Re: Application number SSD-10342

The Royal Agricultural Society of NSW (RAS) are located at Sydney Showground, Sydney Olympic Park and are a very close neighbour of Stadium Australia. We are pleased to provide the following comments concerning the material on exhibition.

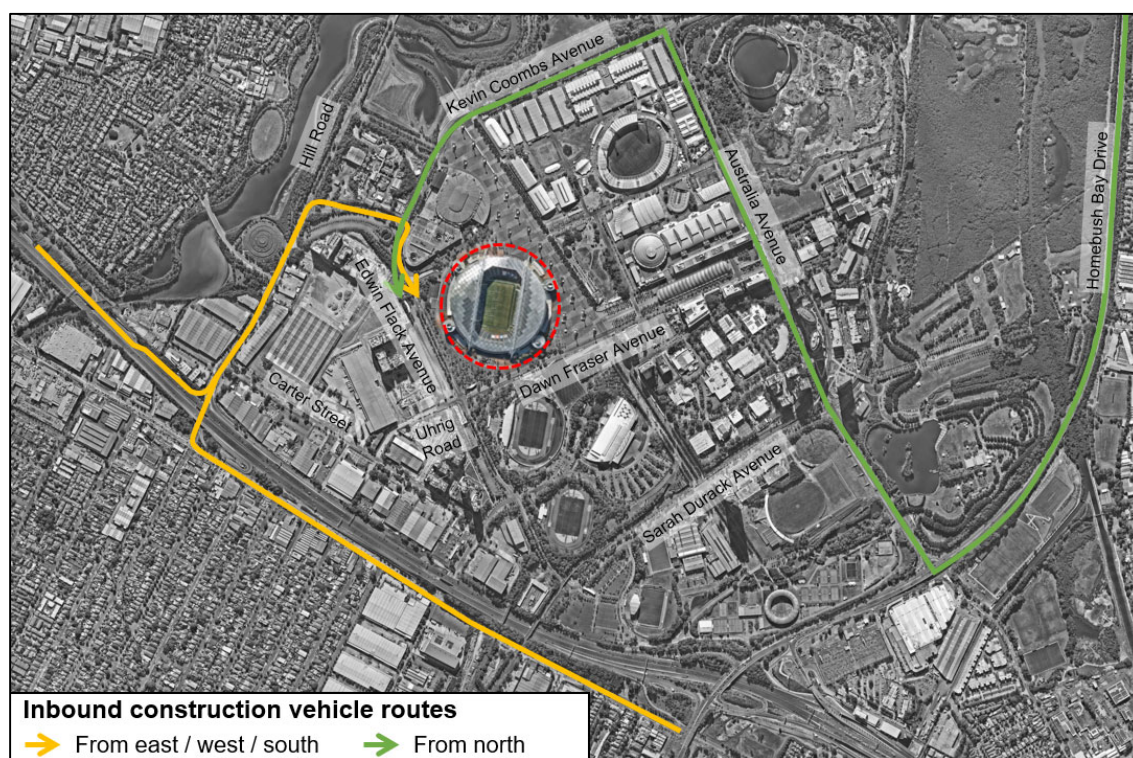
1. As detailed in Fig 52 of the EIS and in various other reports, we note the proposed inbound construction routes from the North along Australia Avenue. Please be advised that for approximately 35 days in and around Easter to facilitate the requirements of the annual Sydney Royal Easter Show (SRES), Australia Avenue from Murray Rose Avenue to Kevin Coombs Avenue is completely closed and will be unavailable to the aforementioned development.

Figure 51 Proposed temporary construction compound

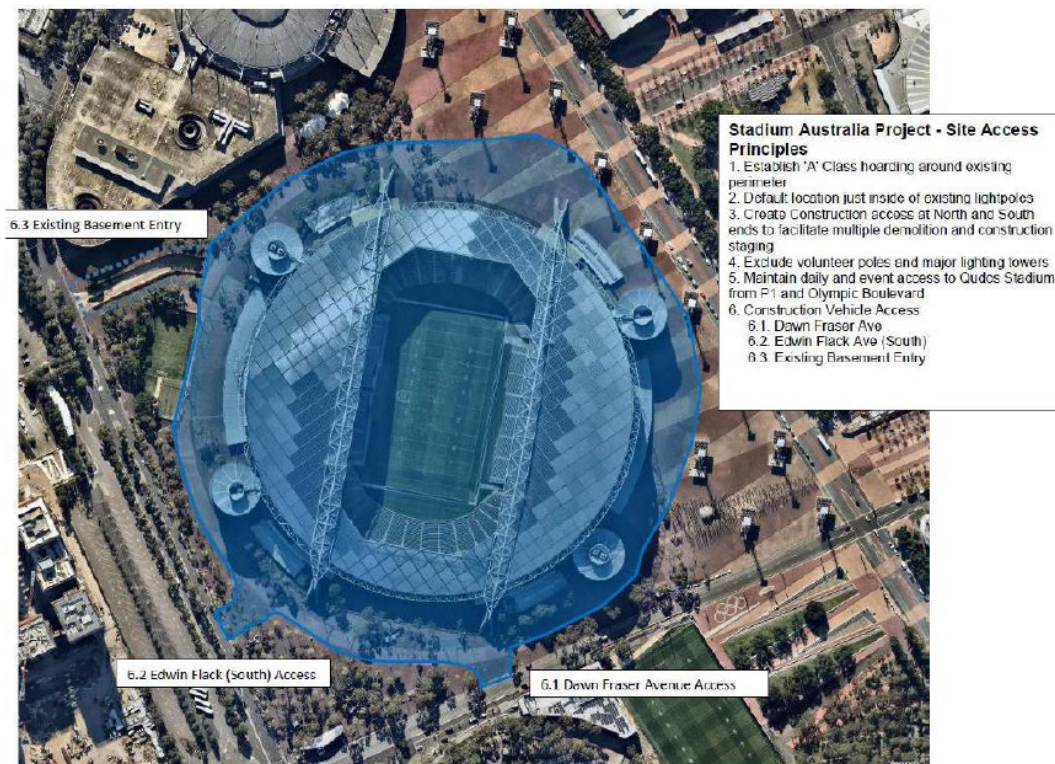
2. We also note the proposed construction boundary fence identified in Fig 51 of the EIS and again in various other reports and advise that discussion and agreement with both the RAS and SOPA will be required as it appears that the proposed boundary to the north west of the site may impact detrimentally on the boundary line of the annual SRES. The RAS would welcome the opportunity to have constructive discussion with the Department to ensure the development can be safely secured without detrimentally affecting the Nation's largest annual ticketed event.
